Development Management
Lincolnshire County Council
County Offices
Newland
Lincoln LN1 1YL
Tel: 01522 782070
developmentmanagement@lincolnshire.gov.uk

Application Ref: H16-0692-25

Proposal: **Development of site to provide a food store and drive-thru, along with all associated works and access**

Location: **Land to the south of Holbeach Road, Spalding, Lincolnshire, PE12 6JP**

Appendix B
Personal Injury Collision Data

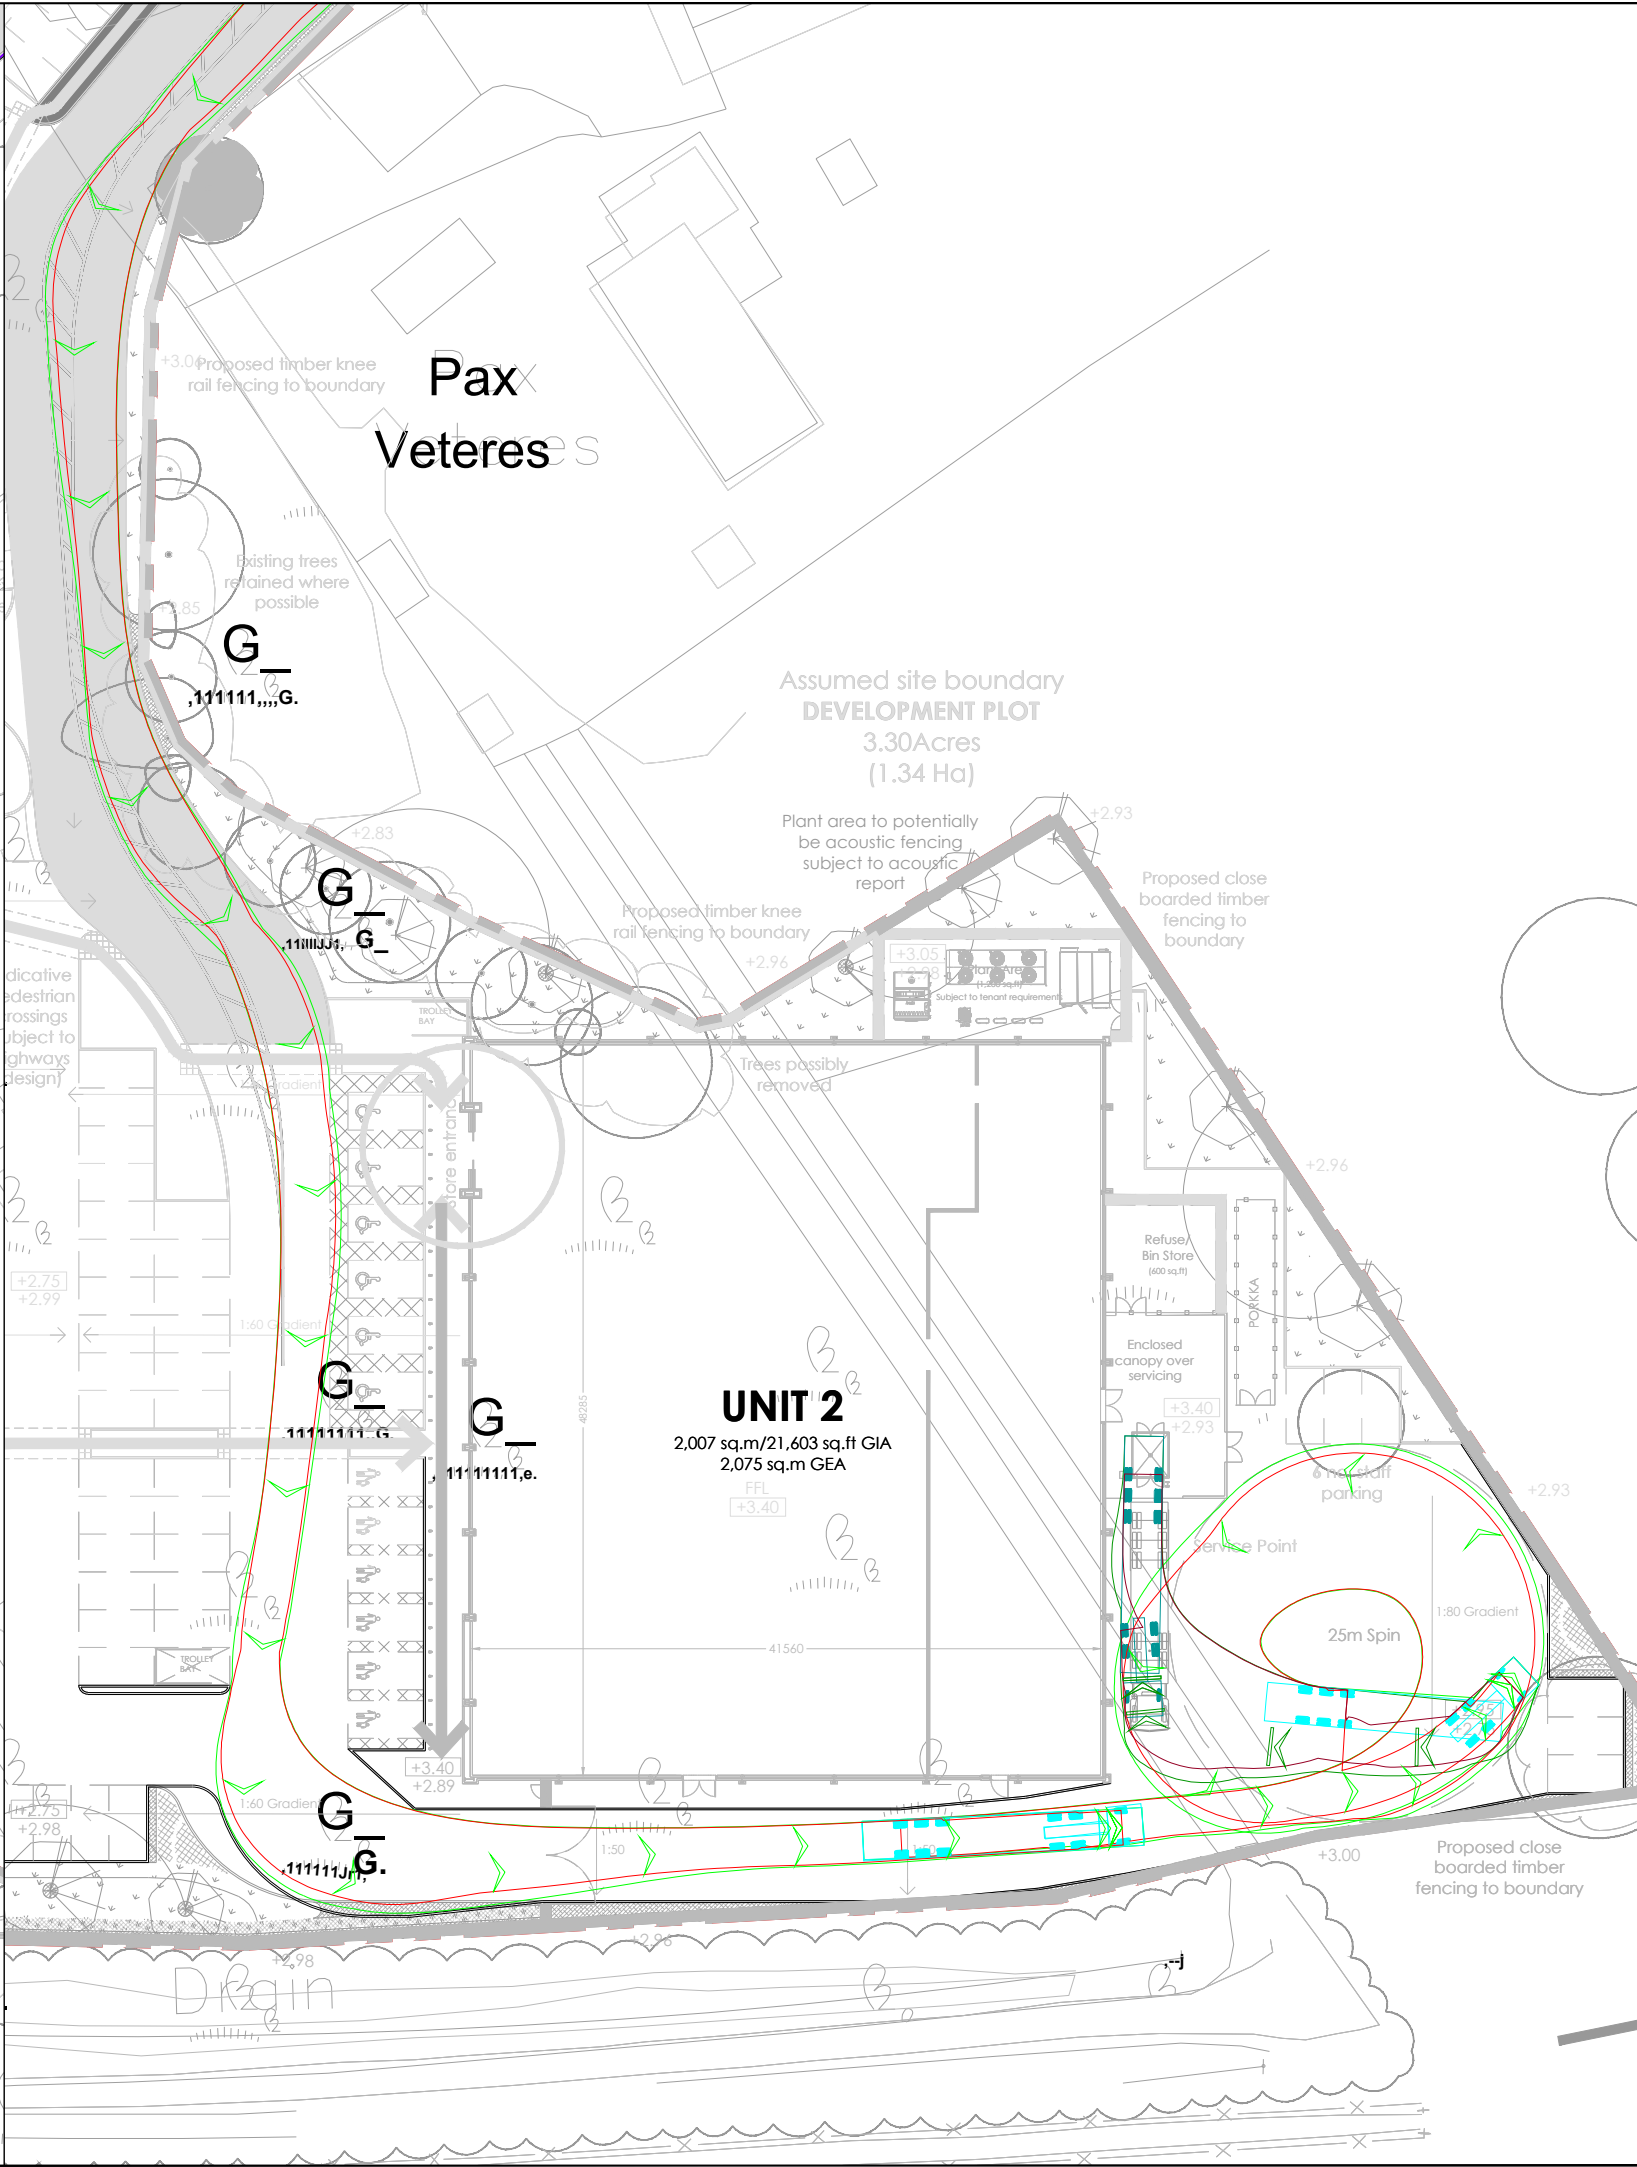
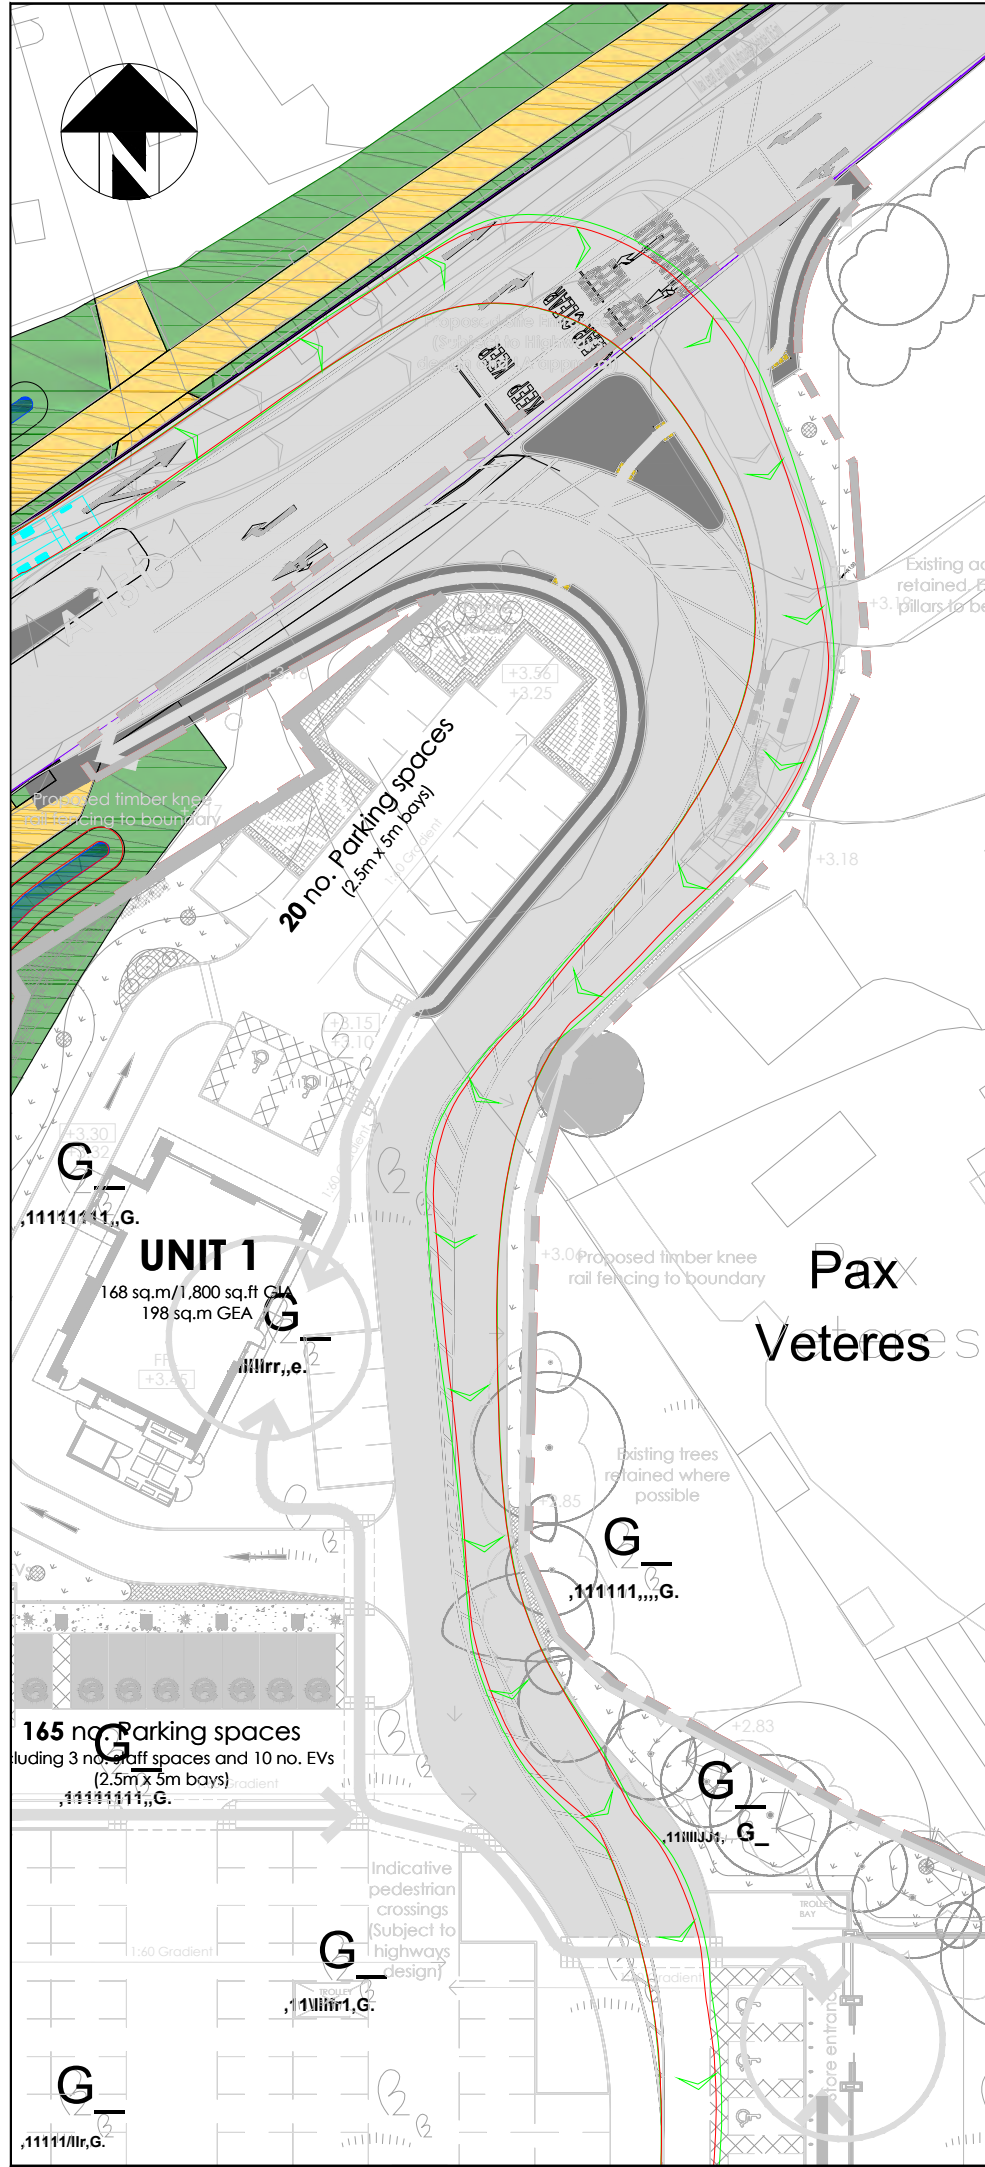
The Transport Assessment does not address safety and the accident data detailed is out of date. Concerns internally with queuing – particularly with it being a Drive Thru and how they operate. There should be a right turn lane internally to the Coffee Drive Thru so that queues internally do not back up into the highway.
